FG/111/20/DOC - Ferringham House - External lighting information and dustbin enclosure

DRAWING TITLE
Overall Site Plan
BUILDING REGS ISSUE

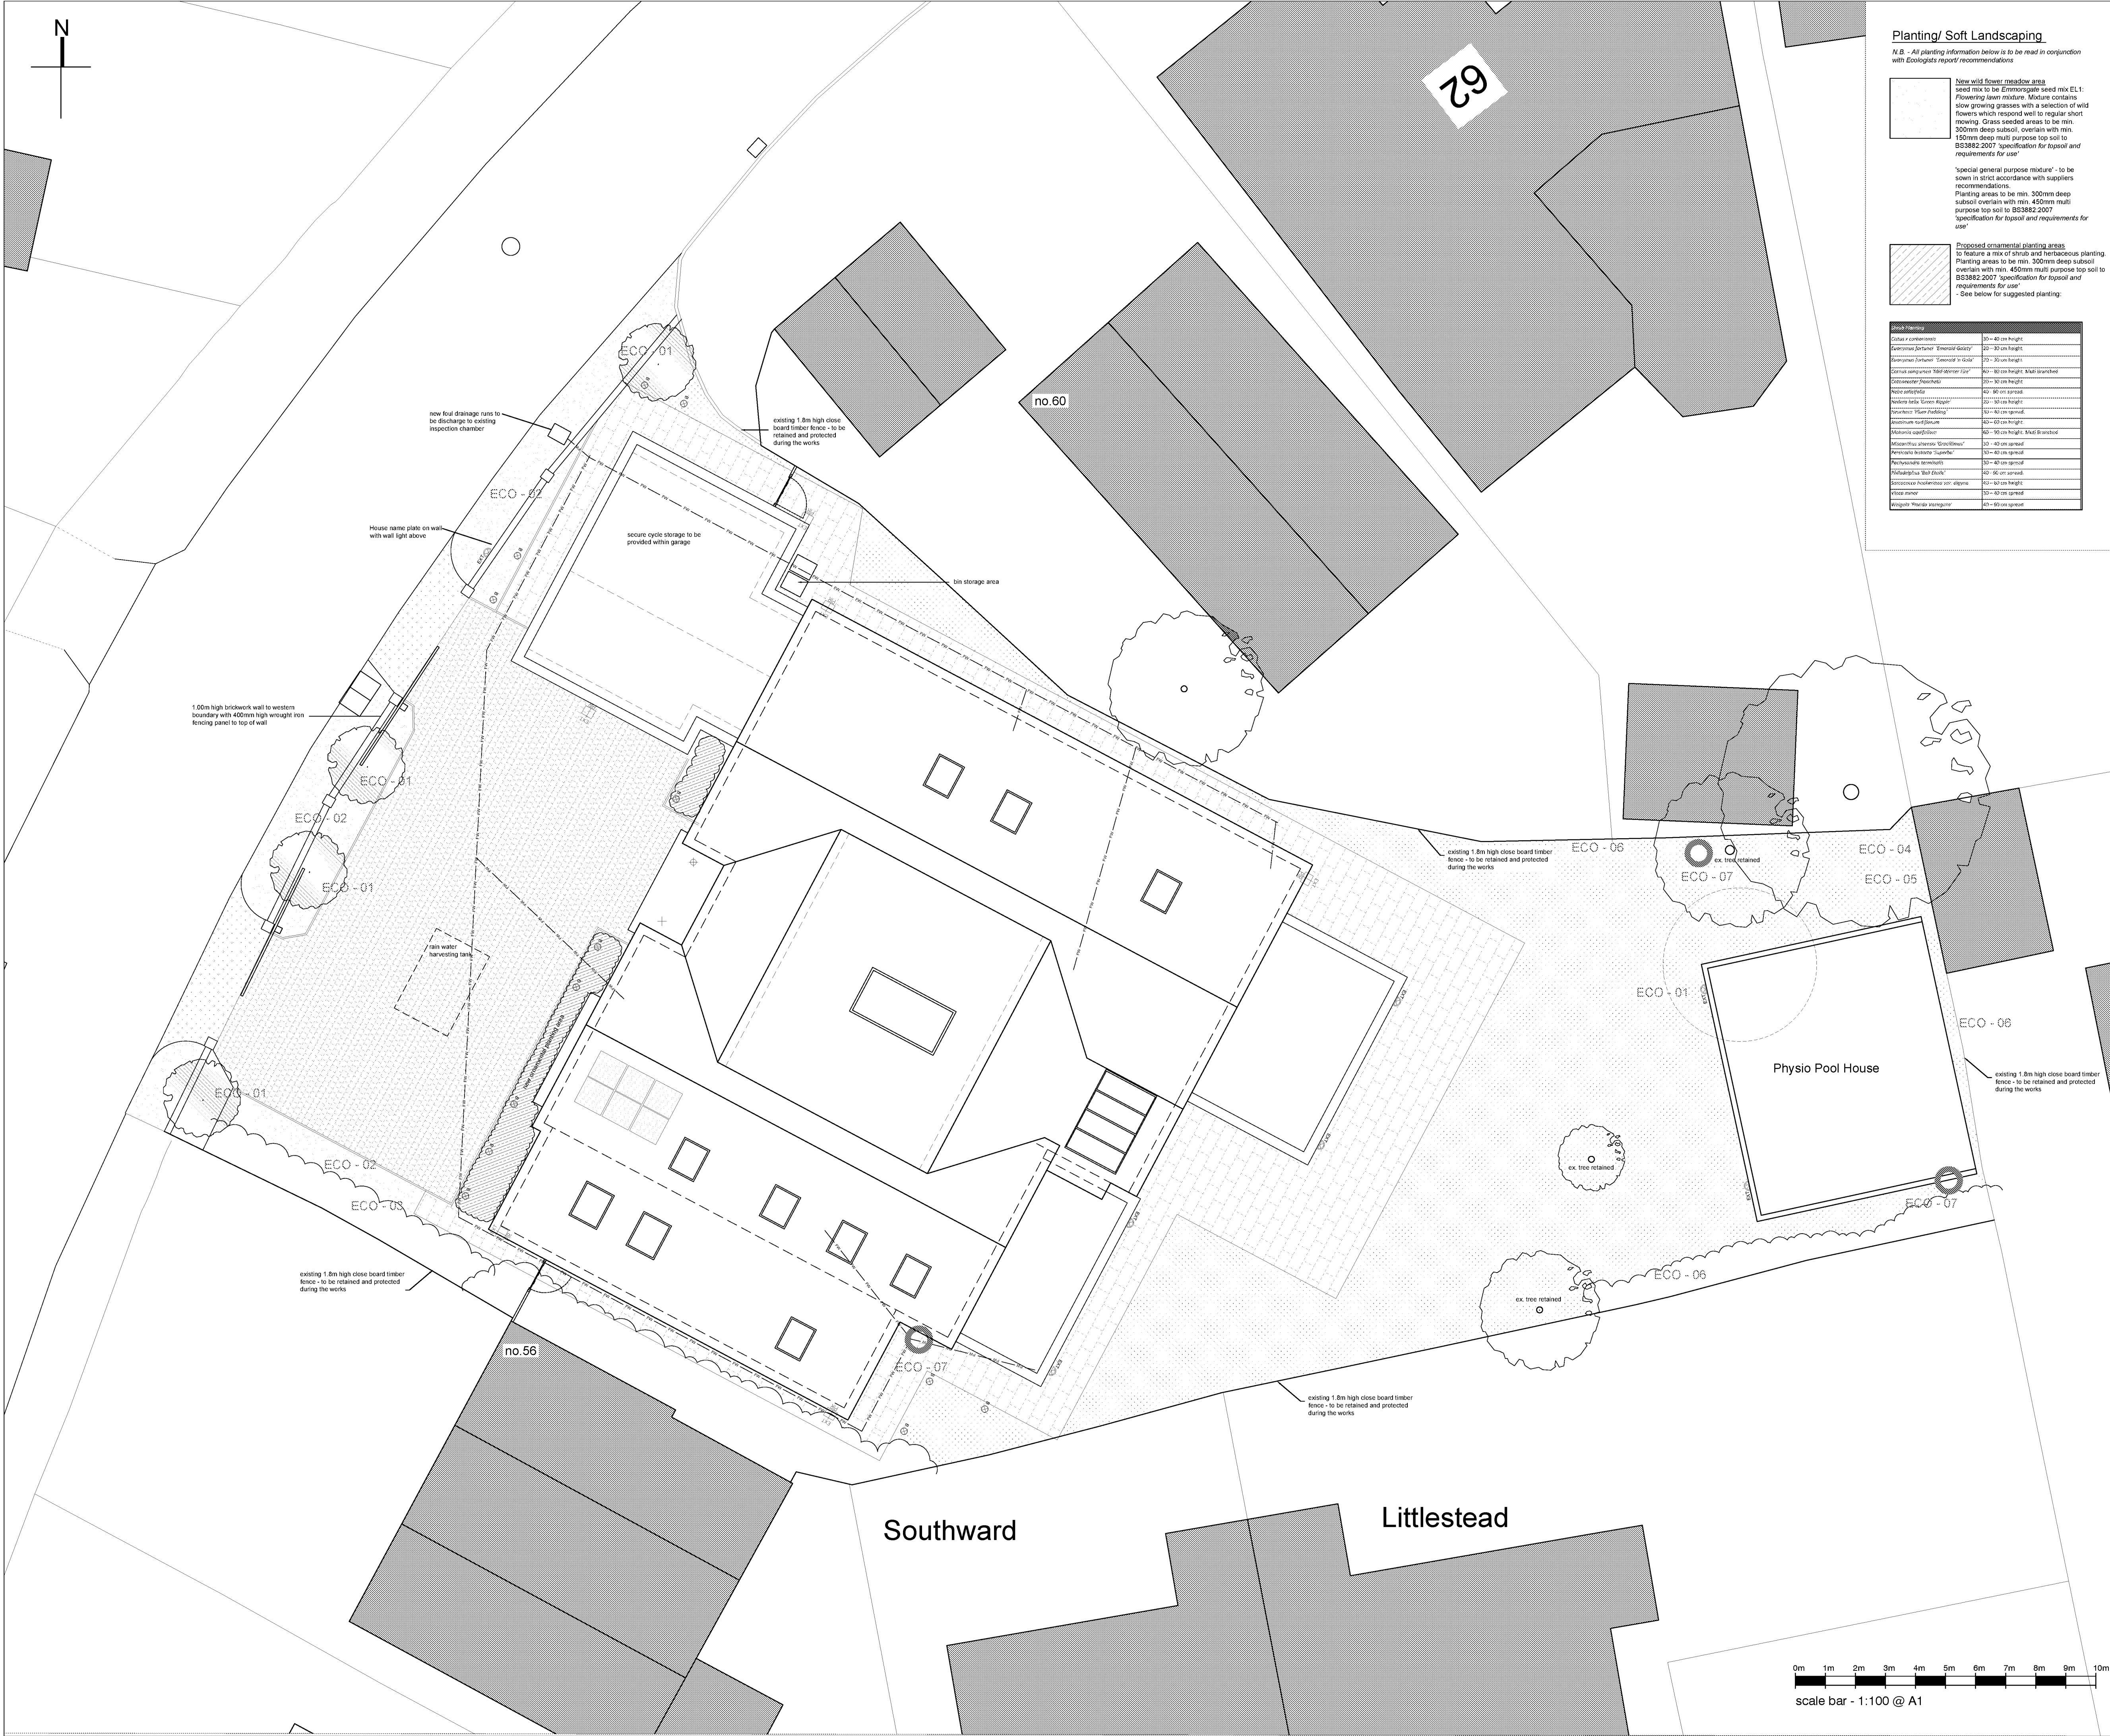
No information has been received regarding external lighting and dustbin enclosure which is required in order to sign off on the condition. Can you please provide the necessary plans and information.

Please find attached a wall and bollard spot light as requested by environmental officer.

Please find attached details of the proposed wall and bollard external lighting units as requested. In regards to the bin enclosure, the bins will be stored outside the utility room tucked behind the garage. They will be hidden from public view so we therefore do not consider the need for a bin enclosure.
